NATURAL ENGLAND DESCRETIONARY ADVICE CORRESPONDENCE

Development proposal and location: Hillingdon Water Sports Facility and Activity Centre (HWSFAC), Broadwater Lake.

Date: 06 December 2023
Our ref: 458158
Your ref: 2382/APP/2023/2906

Planning consultation: Redevelopment of the site to create the Hillingdon Watersports Facility and Activity Centre including demolition of existing Broadwater Lake Sailing Club (BSC) clubhouse at the north of the lake and erection of a building and facilities to be occupied by HOAC and BSC

Figure 7.2: Units of Mid-Colne Valley SSSI

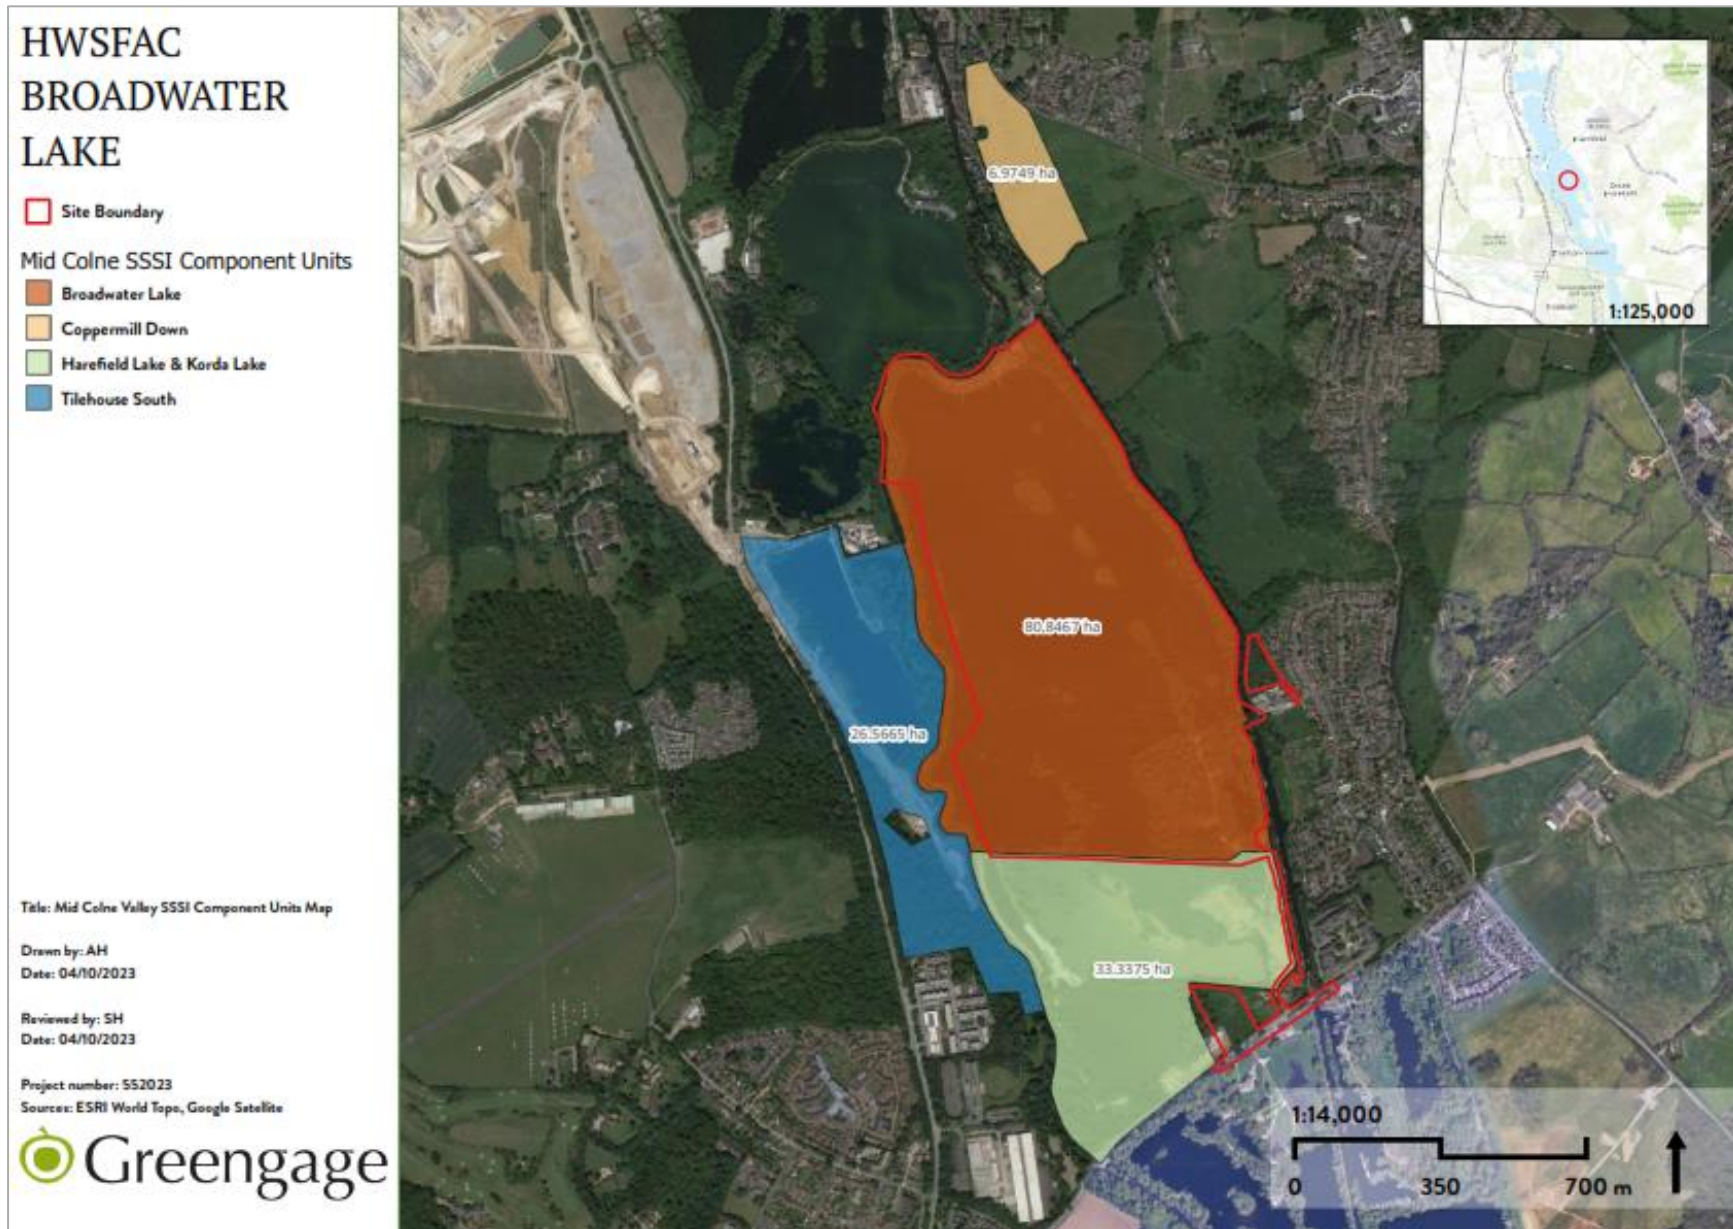
Mid Colne Valley SSSI is made up of four sites; Coppermill Down, Harefield Lake and Korda Lake, Tilehouse South and Broadwater Lake. Broadwater Lake is the largest of the lakes within the SSSI and therefore an integral component of the whole SSSI. Broadwater Lake is an important site for birds as it acts as a refuge from disturbance arising at Broadwater Lake itself or from other waterbodies in the vicinity. Although Natural England have focussed on the impacts of the proposed development in relation to the aggregations of non-breeding birds and on the assemblages of breeding birds, the full list of the interest features for which Mid Colne Valley SSSI has been designated include the following:

- Aggregations of non-breeding birds - Tufted duck, *Aythya fuligula*
- Aggregations of non-breeding birds - variety of wintering species
- Assemblages of breeding birds - Mixed: Lowland open waters and their margins, Lowland fen and Lowland damp grassland
- Assemblages of breeding birds - Mixed: Scrub, Woodland
- Assemblages of breeding birds - variety of species
- Lowland calcareous grassland (CG3-5)
